From: Sarah Burrow
Sent: 08 April 2021 12:49
To: Planning.Responses
Cc: Zoe Toppin
Subject: RE: Planning Consultation on: M/17/21/HH

Engineers Comments Regarding Surface Water Drainage

Application No: M/17/21/HH
Registered: 18th February 2021
Site Address: 14 North Avenue South Ancton Middleton-On-Sea PO22 6HE
Grid Reference: 498016 100294
Description of Works: Single storey side and rear extensions.

Proposed Ground Floor Plan

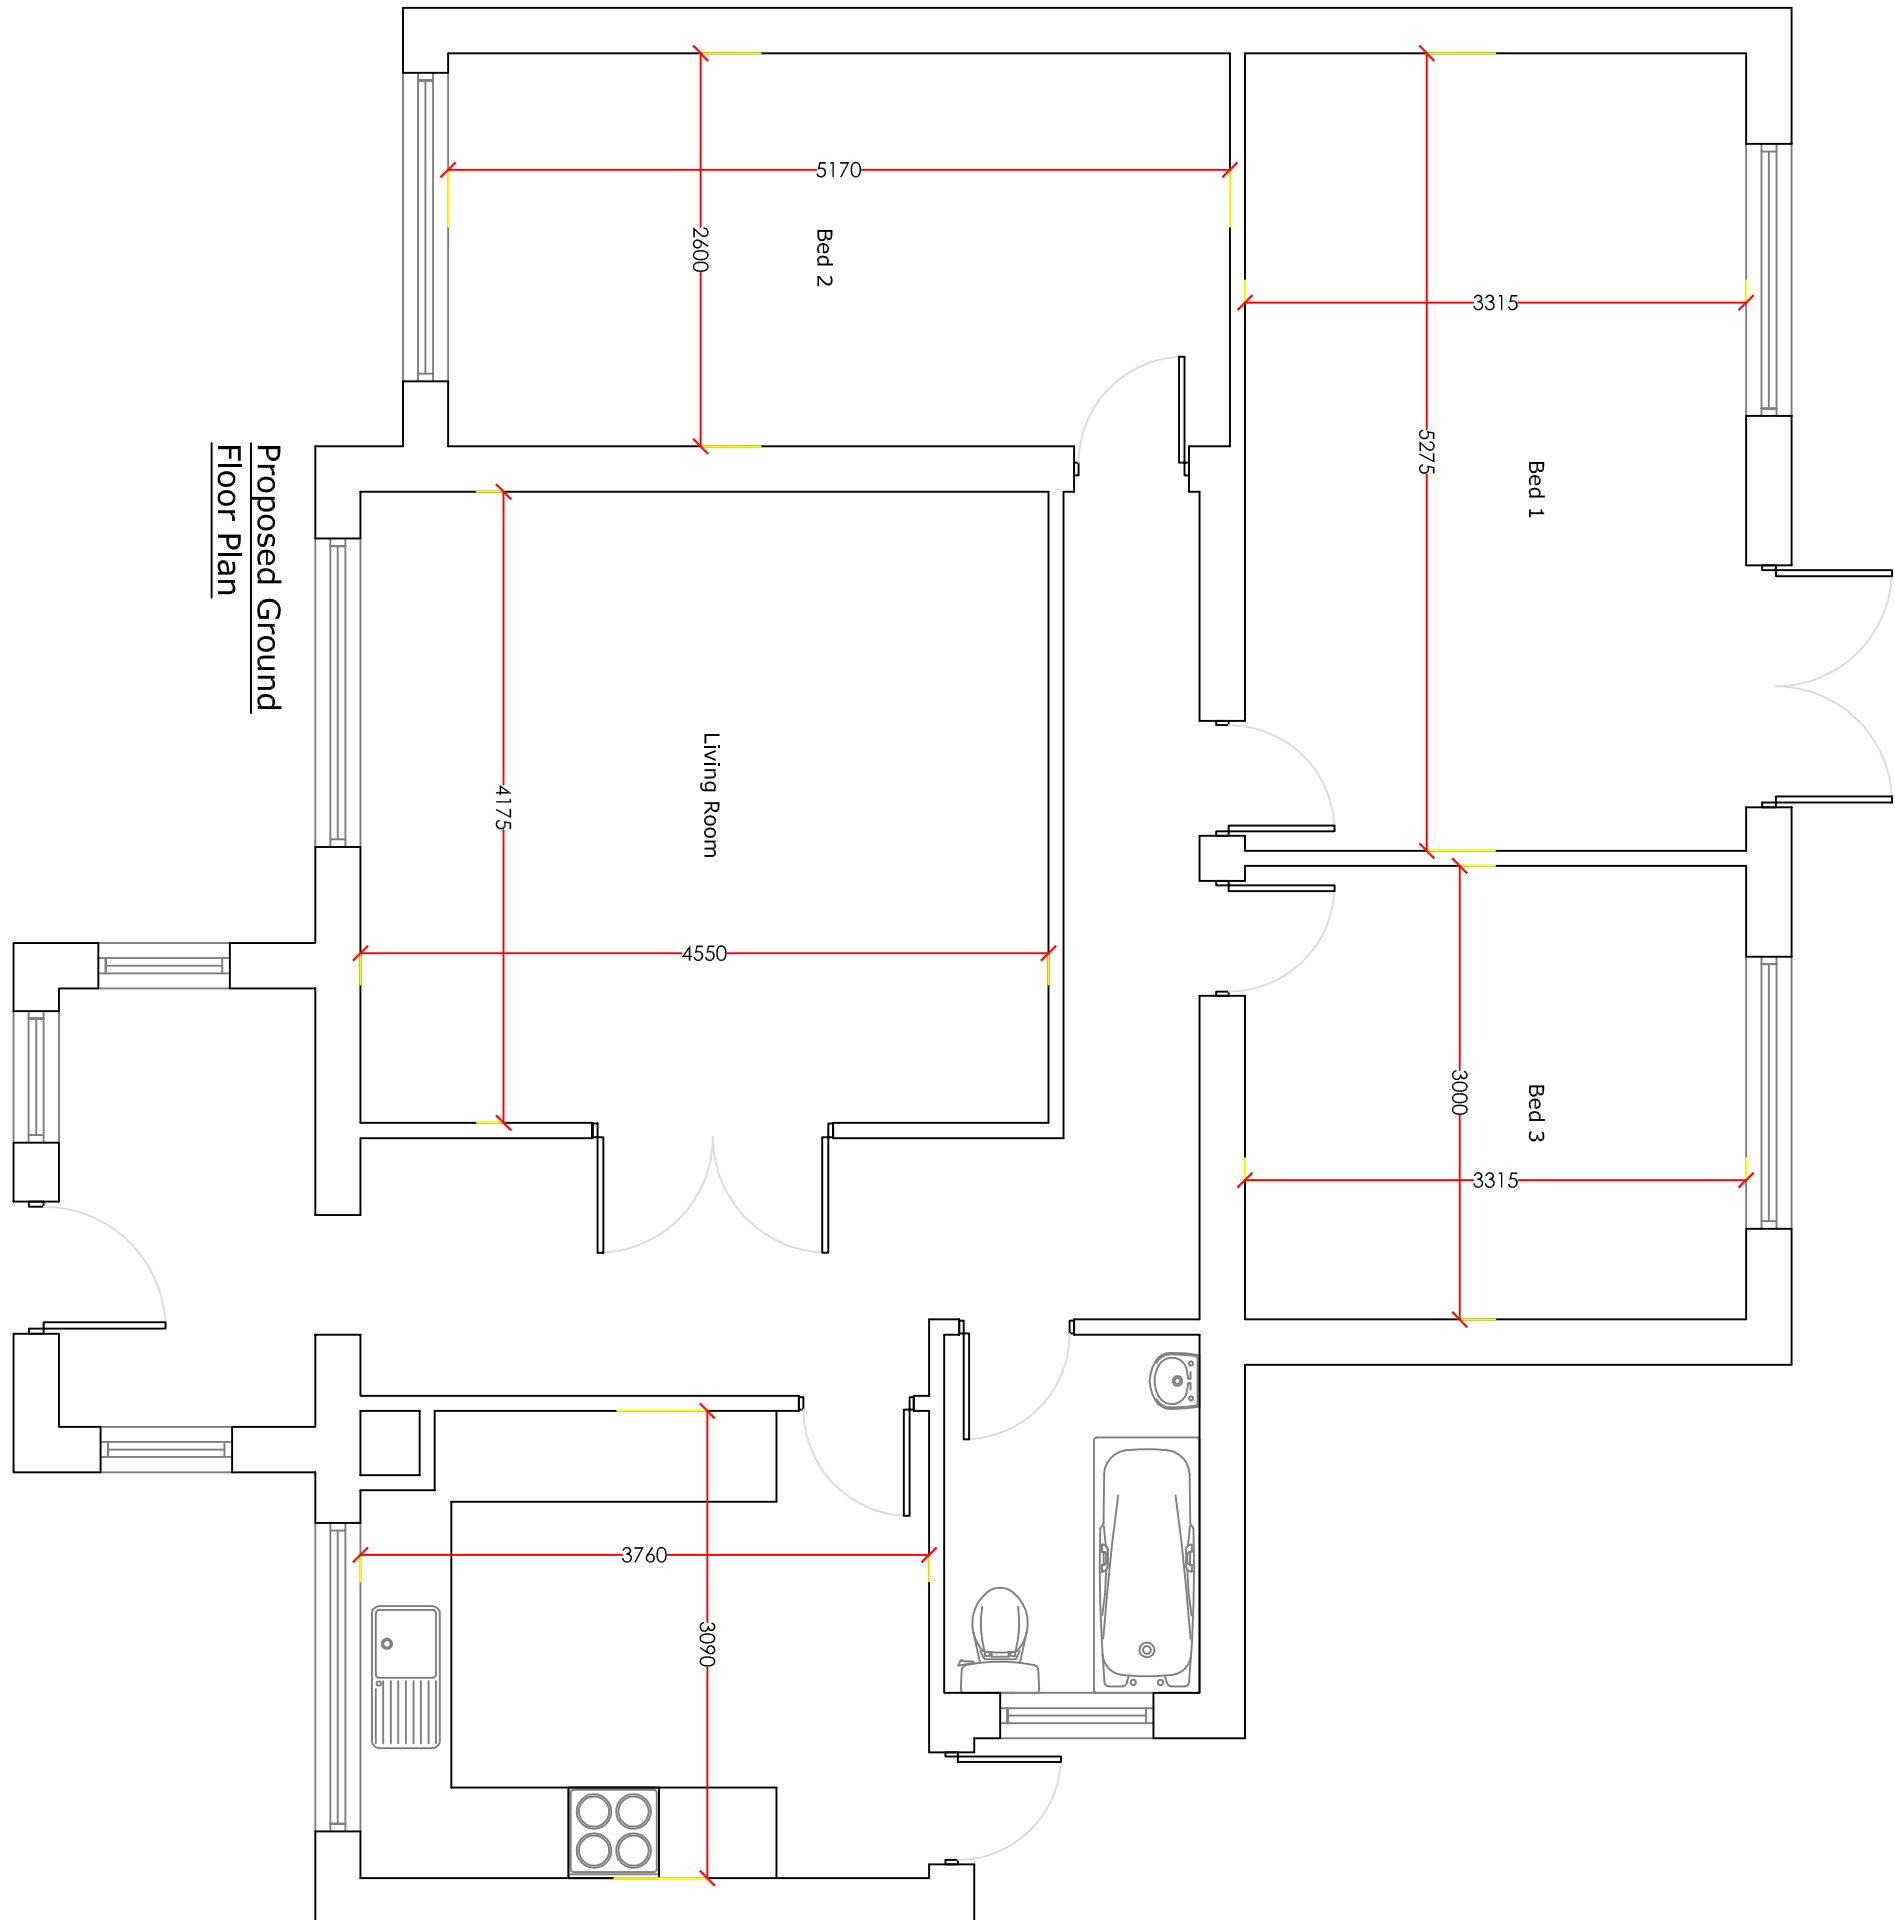
According to our mapping there may also be a foul water sewer running through the rear garden in the location of the proposed extension. Southern Water should be consulted regarding the location of this sewer and any easements, diversions, or build over agreements that may be required.
